Your Ref: OWPC21642
Our Ref: AW/42/19/HH 01-02-2019
Please ask for:
Amber Willard

Front canopy, alterations to external finishes & balcony balustrade. This application affects the character & appearance of the Craigweil House Conservation Area.

25 The Drive Aldwick

sheet 4 of 4

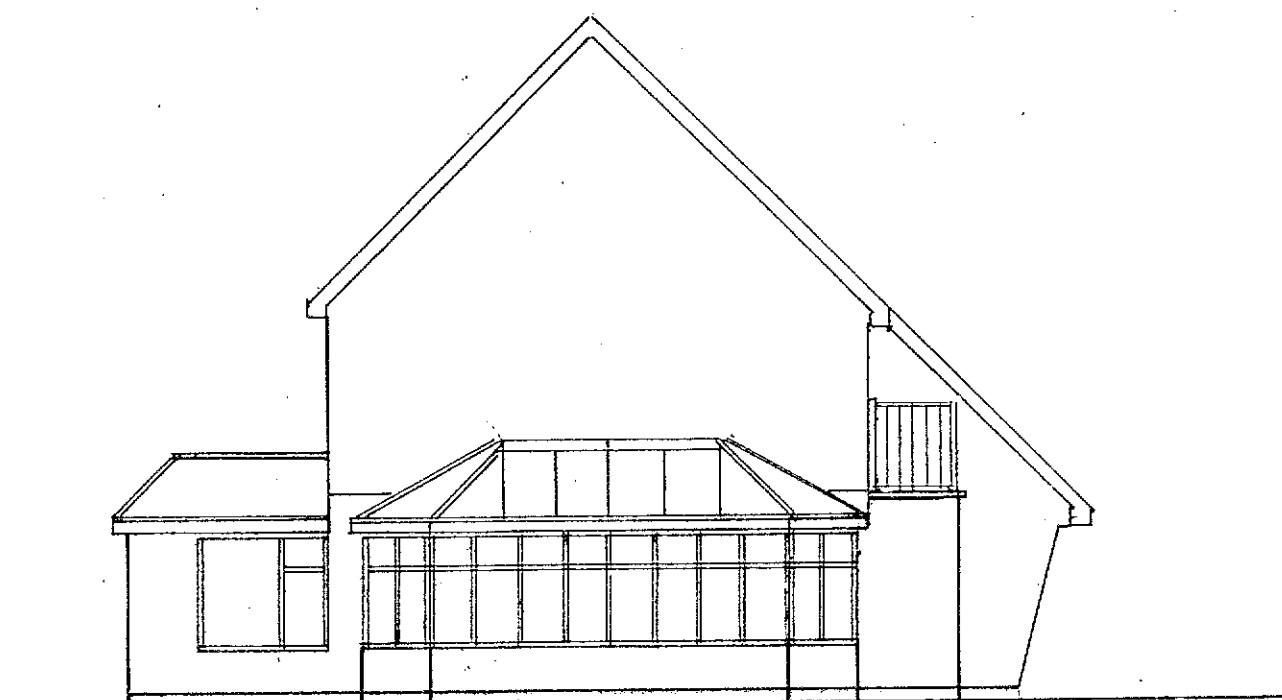
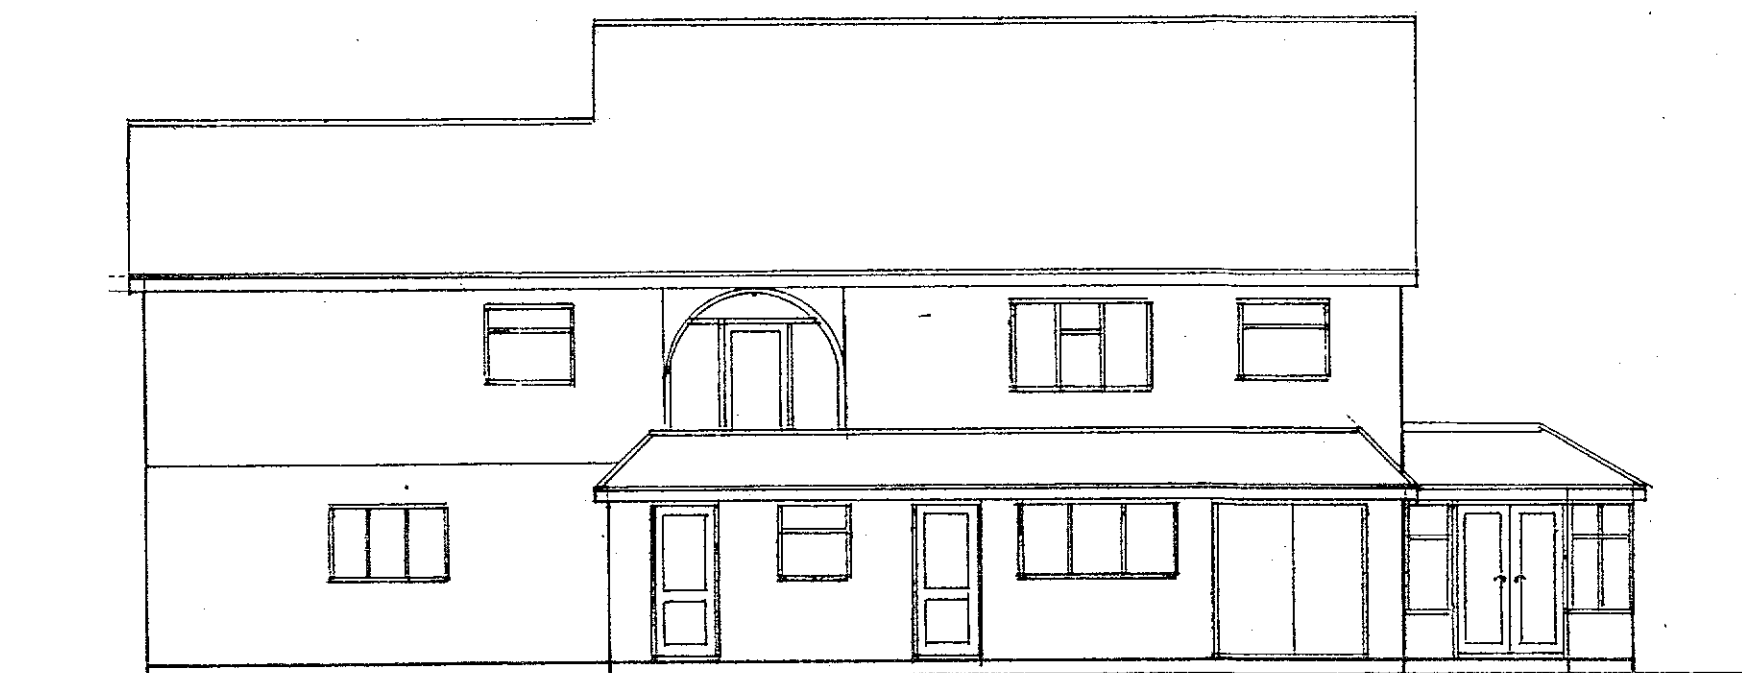
My main objection relates to the balcony balustrade. There are three similar houses with similar public facing balconies on this separated part of the conservation area - two of these are on either side of the applicant's house. These houses all have similar frontages with wrought iron balconies which add a degree of coherence to the overall location and add to the consistency of the conservation area. The proposed white painted, criss-cross panels, would be completely out of character with all, but particularly these dwellings and unsympathetic to this part of the conservation area.

The application makes reference to cladding and render and although it is not clear from the plans as to how much of the building will be covered with these, should they cover the front of the house, they would completely alter the street scene in this part of The Drive. In this part of the conservation area, there are buildings with "feature" areas of cladding and whilst not objecting to these, the coverage of whole walls by cladding and render would make this house completely out of character with similar properties and with this part of the conservation area.

The existing east elevations shown on the plans show two windows at the ground floor level one of which has been omitted on the proposed elevations although it is not apparent as to whether this removal is included in the application and this requires clarification.
